RE: Staff Review Comments for Preliminary Level II Site Plan

Project Name: Century Tire Plaza  
Address: 195 Kennebec Street  
Applicant: Northland Enterprises, LLC  
Planner: Nell Donaldson

Project ID: 2015-027  
CBLs: 34-C-9

FST 100 YEARS	FAY, SPOFFORD & THORNDIKE ENGINEERS - PLANNERS - SCIENTISTS 778 MAIN ST., SUITE 8, SOUTH PORTLAND, ME 04106
DRAWN: KGS	DATE: 6/9/15
DESIGNED: ADJ	SCALE: AS NOTED ON PLANS
CHECKED: ADJ	JOB NO: 15-018
FILE NAME: SP-1	SHEET: C-7.0

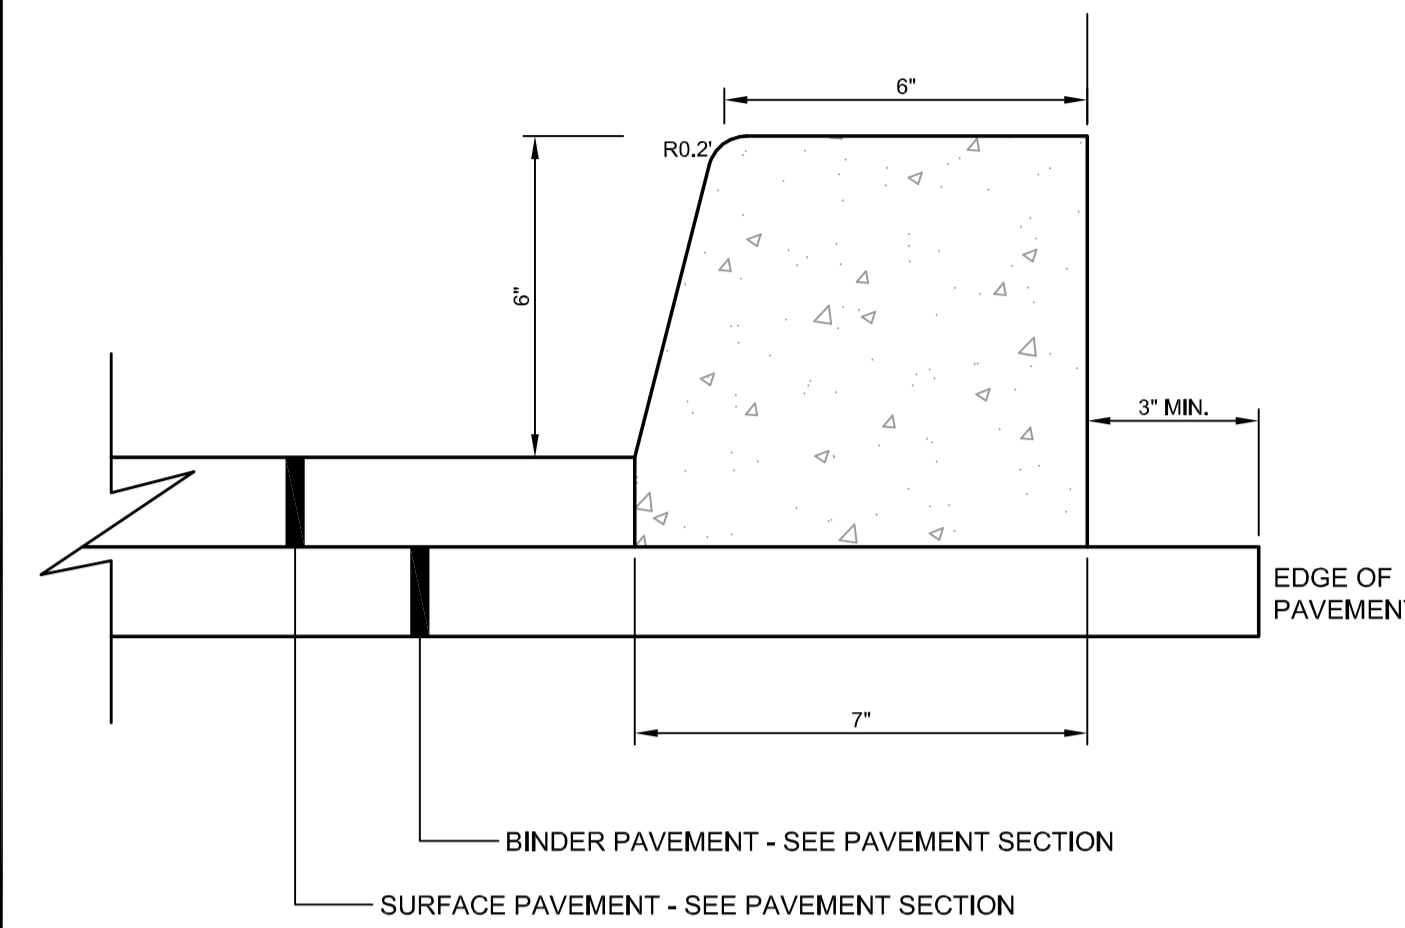
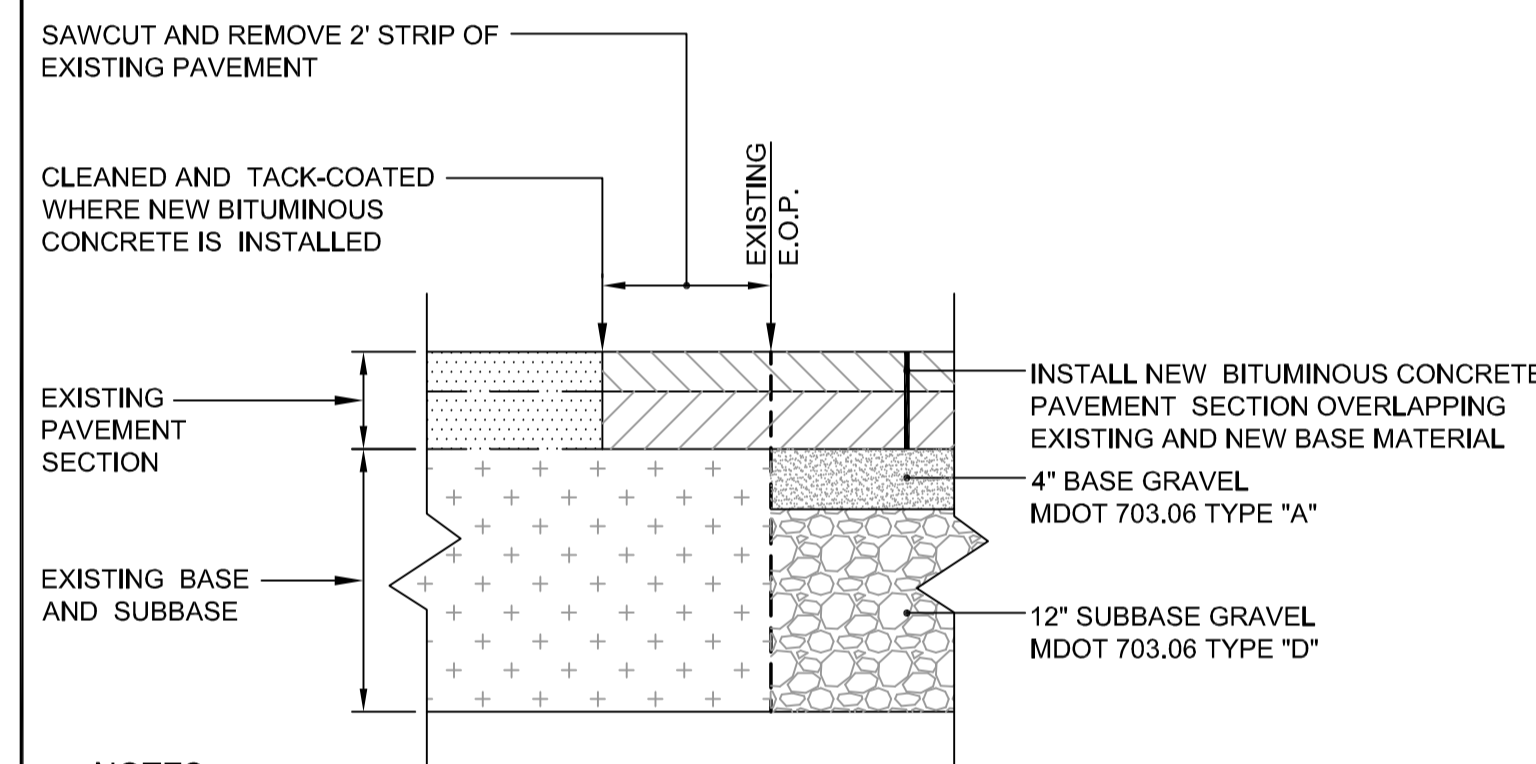
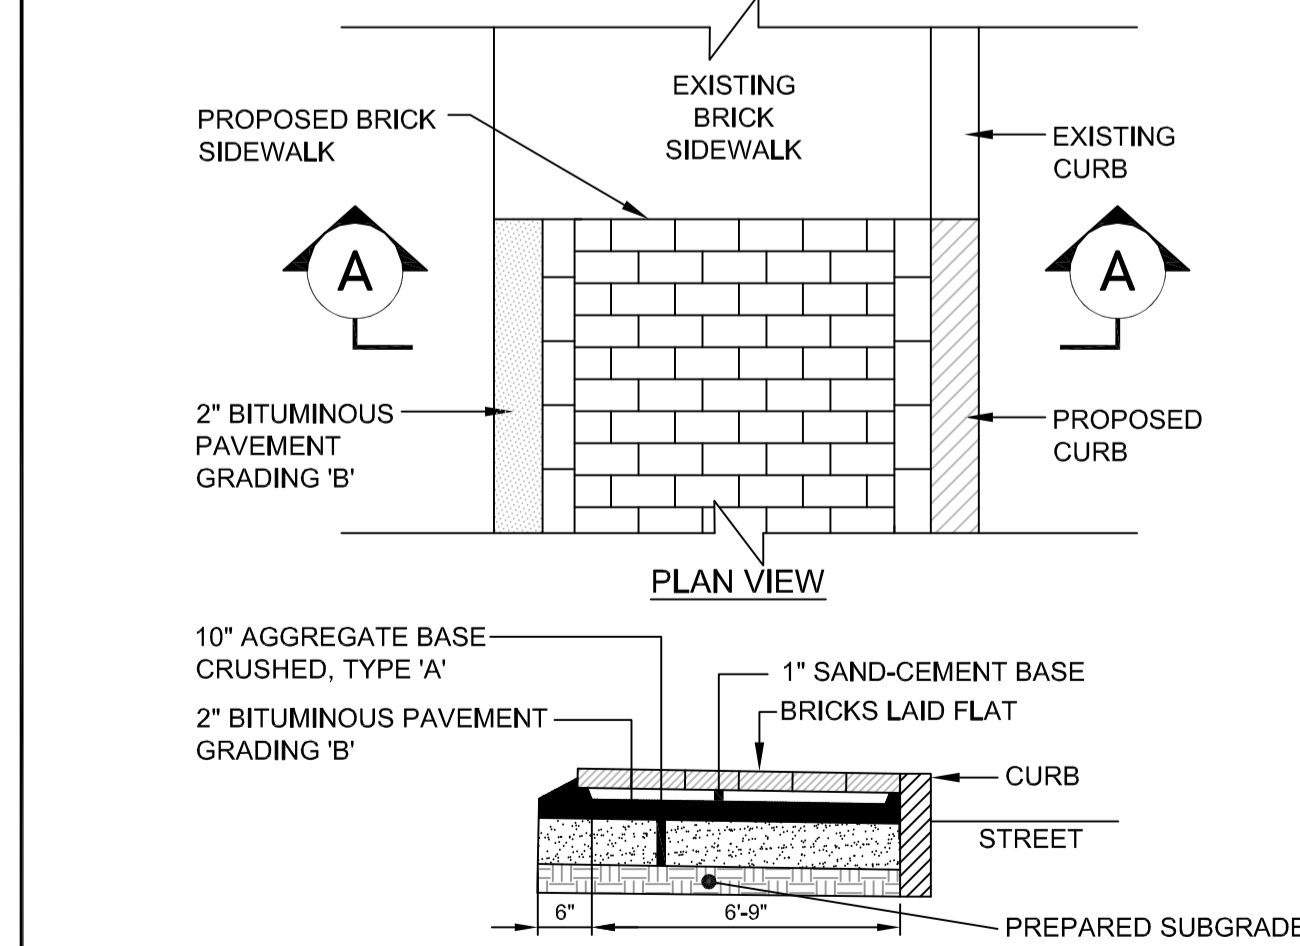
*The curbing material standard within the road right of way for the City of Portland is granite. Concrete is indicated on Kennebec St.*

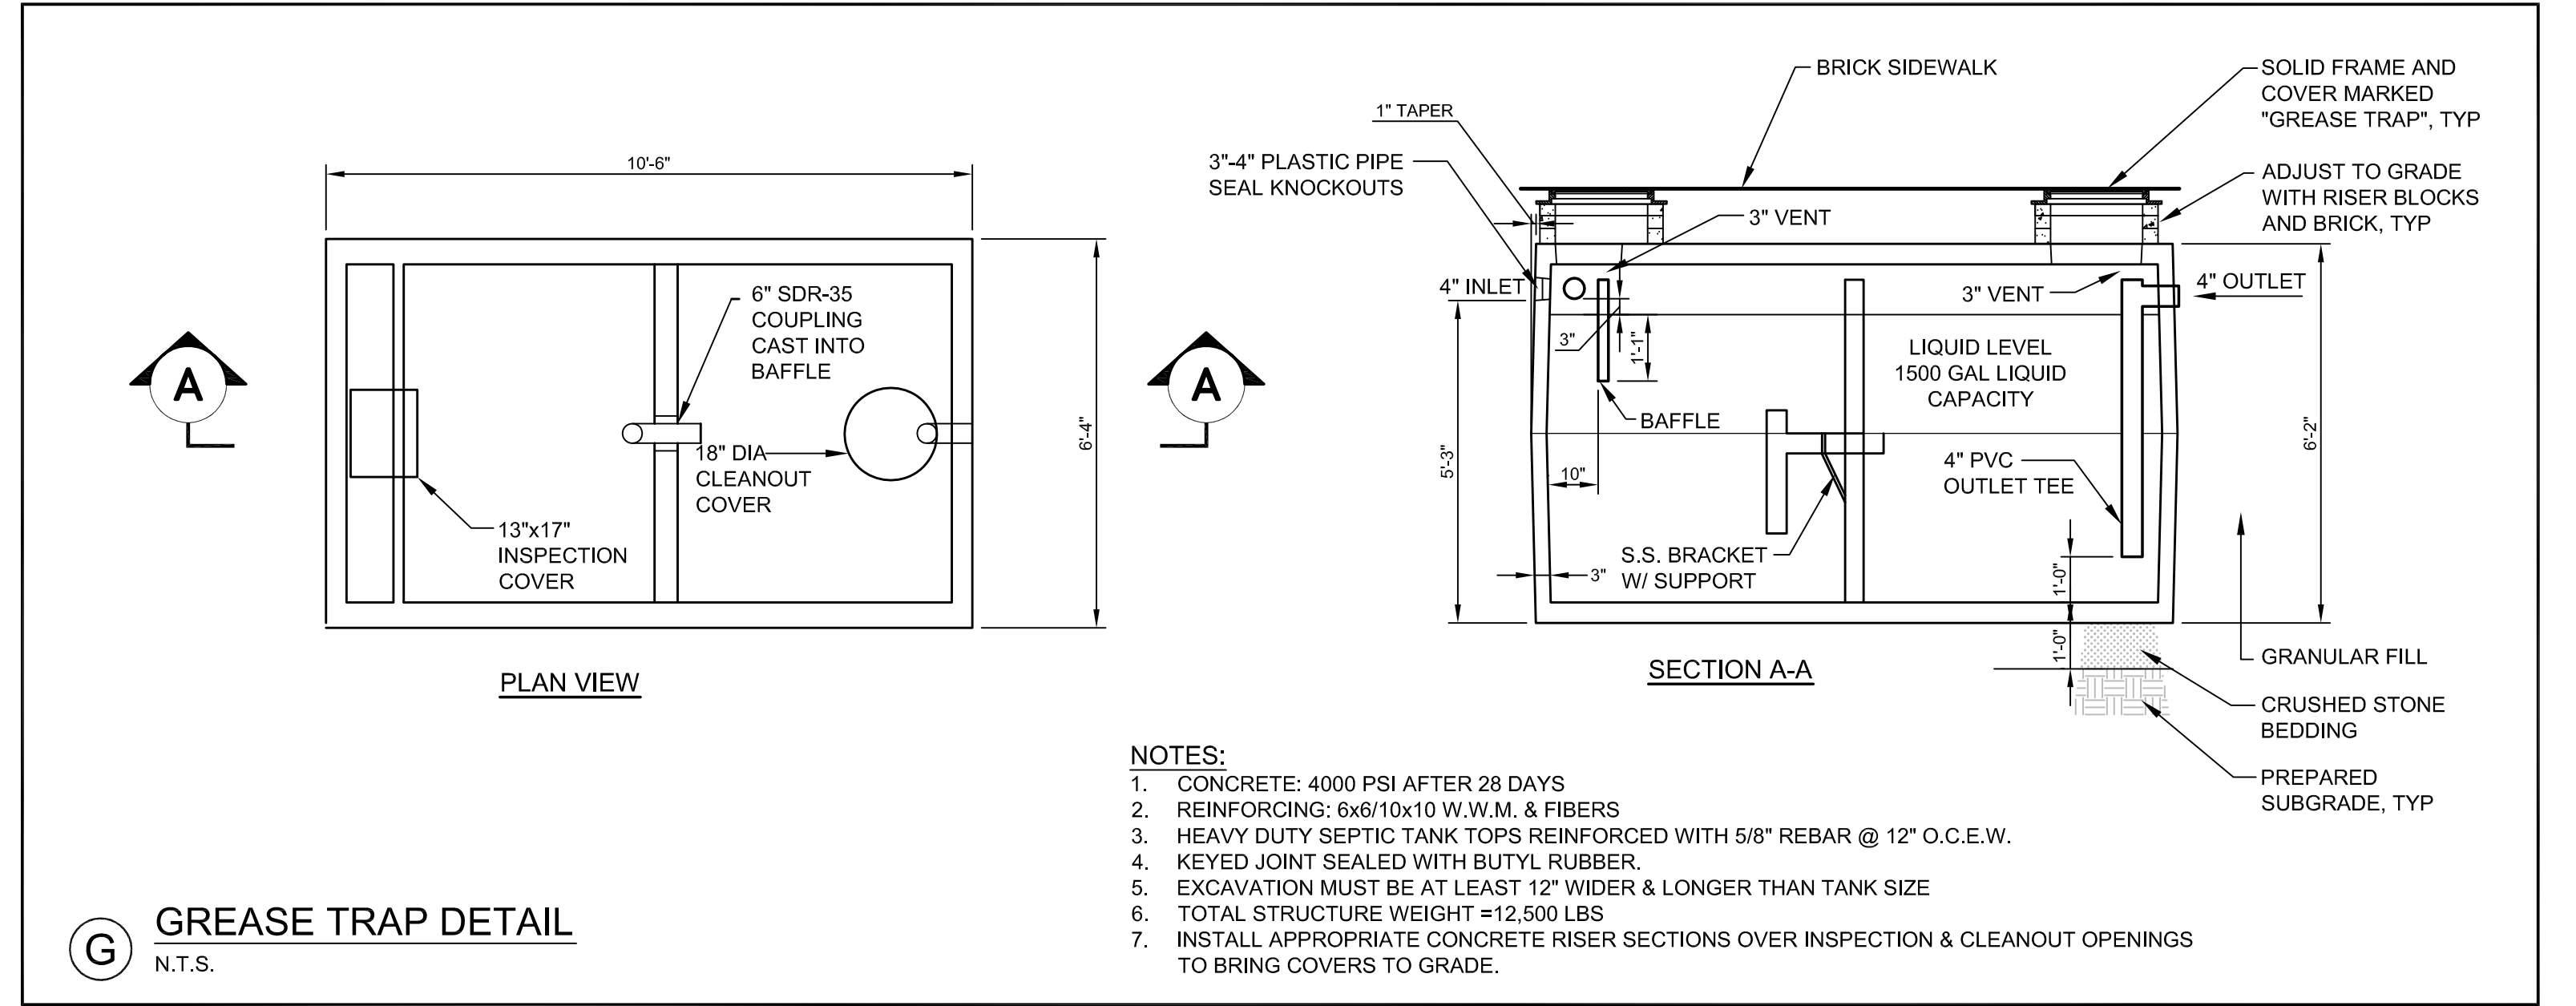
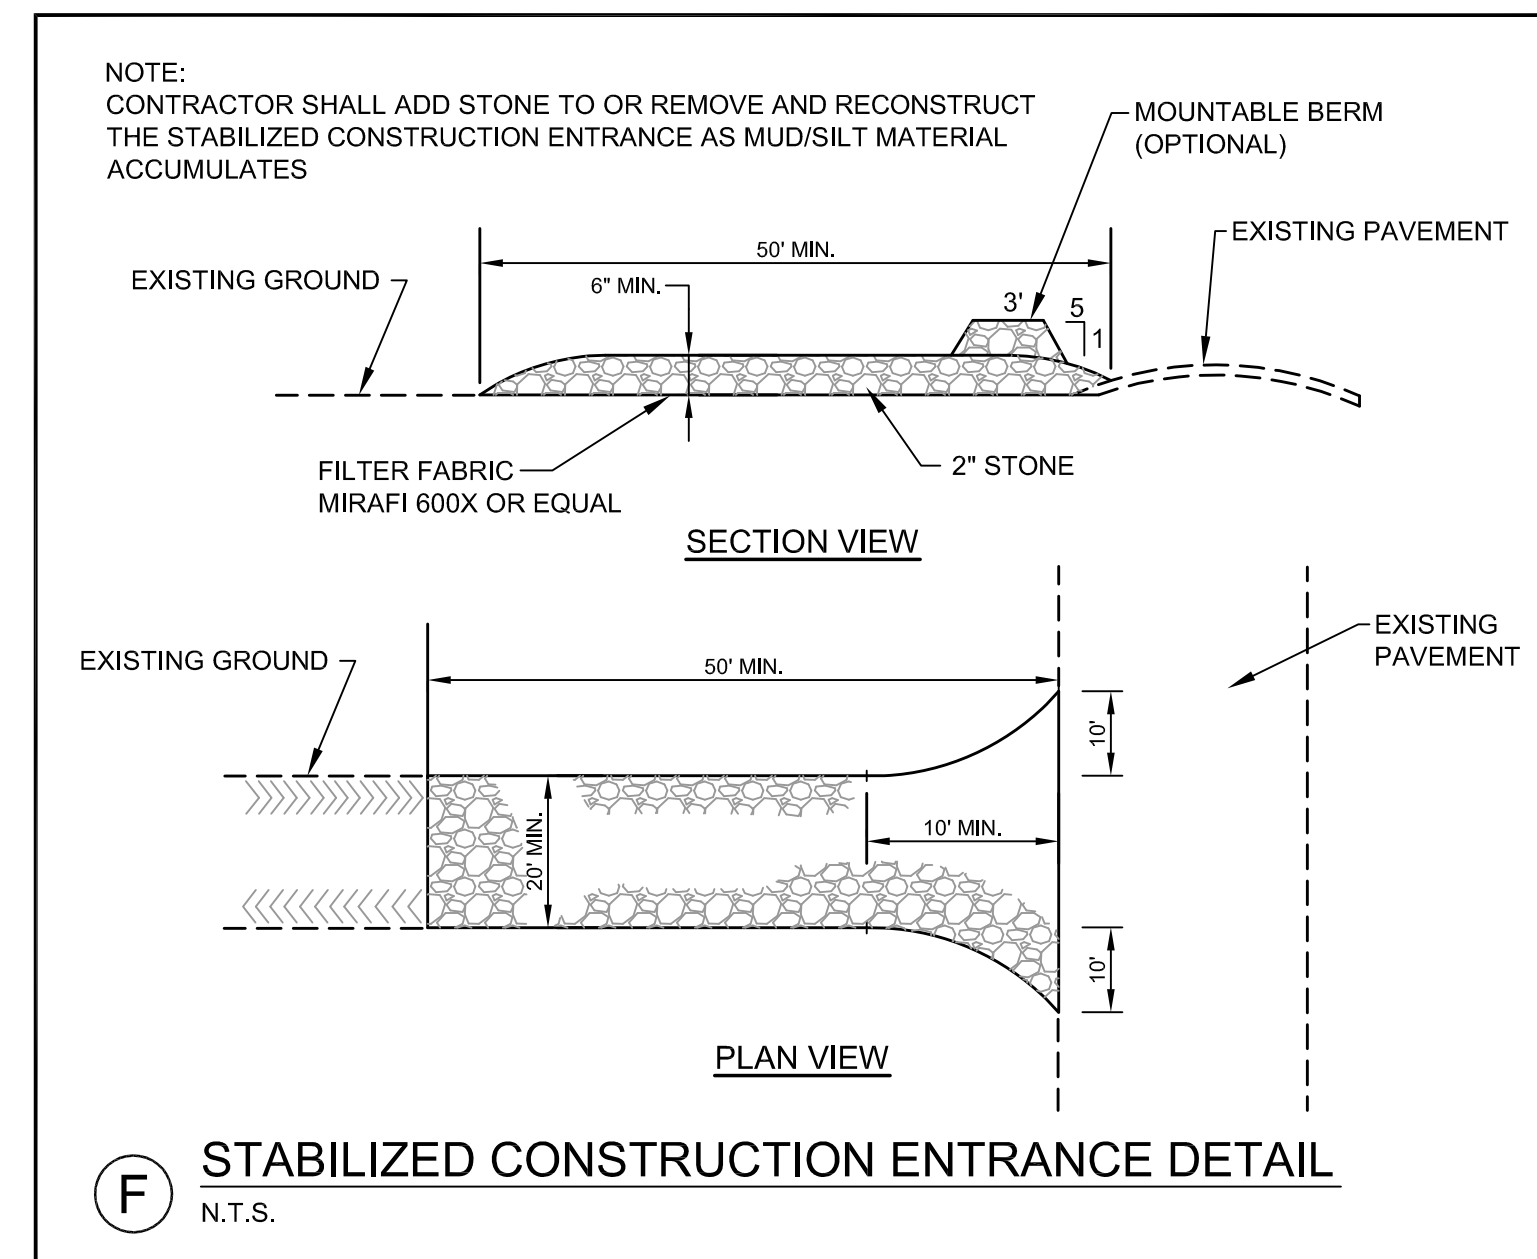
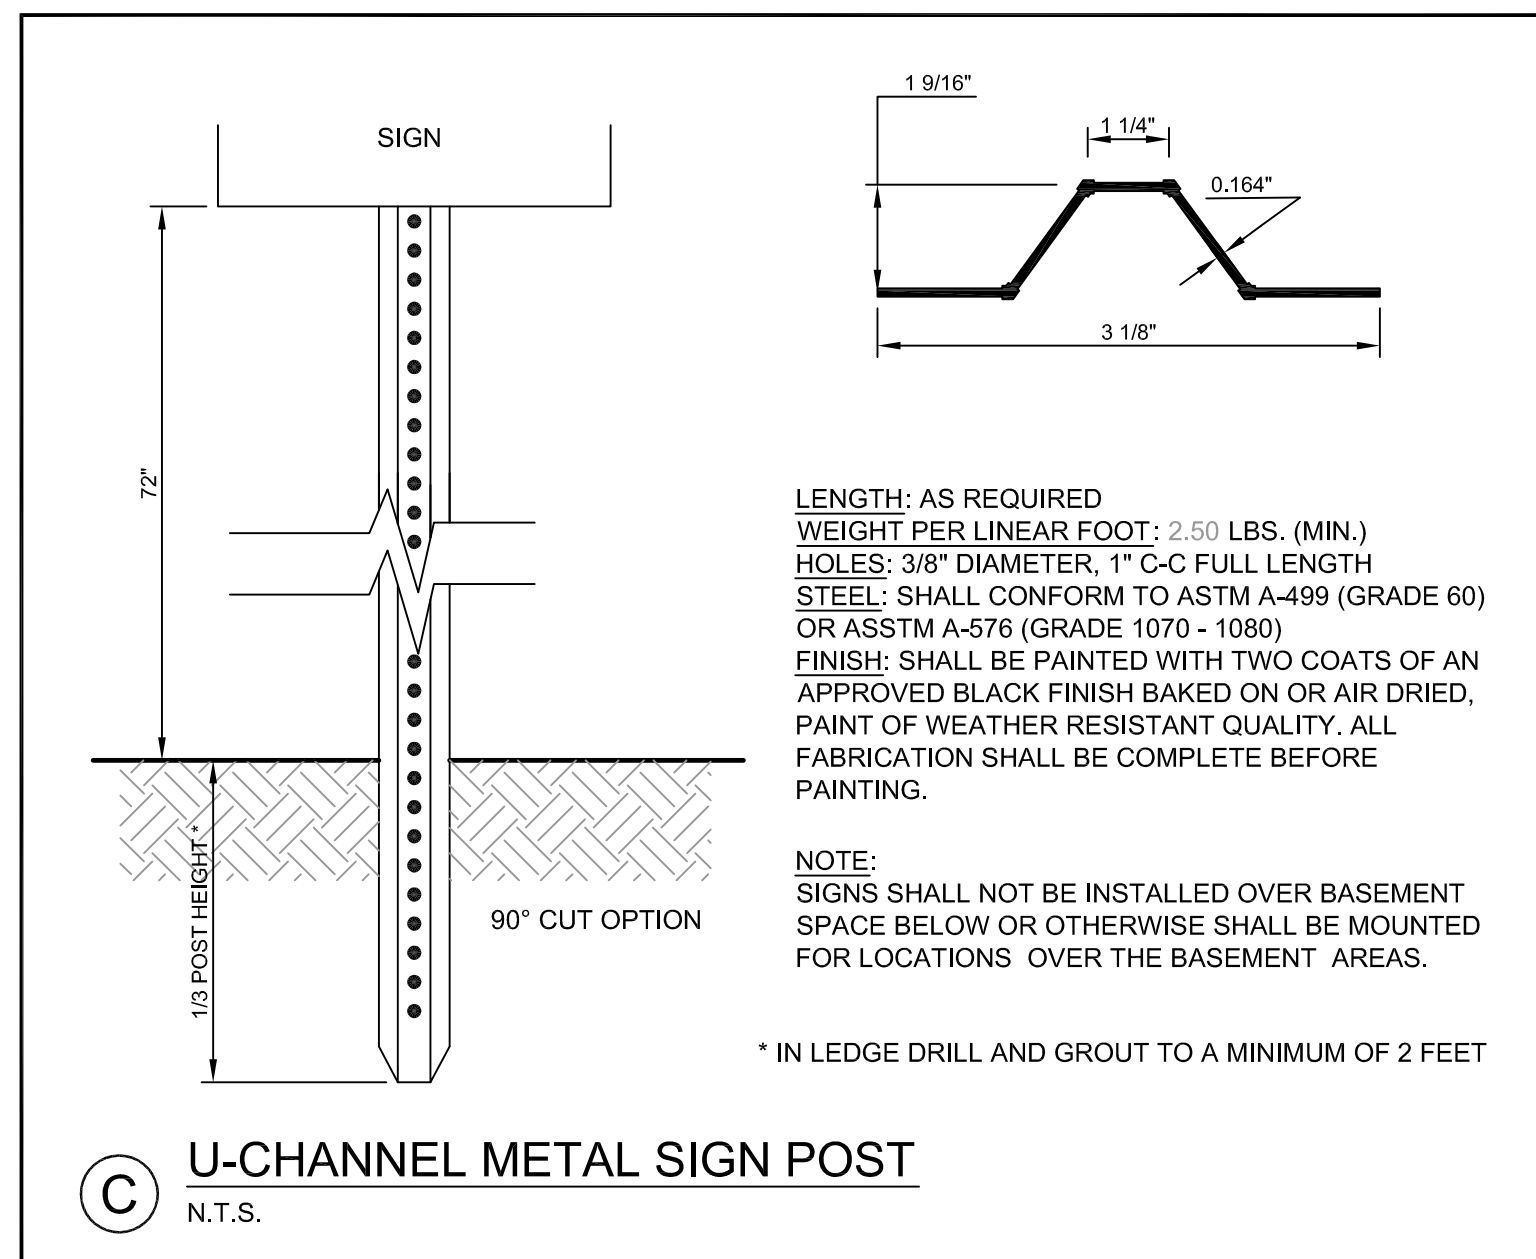
*The bike parking concrete pads should be a minimum of 8' in length and 6' in width (9'x6' better) to ensure their functionality.*
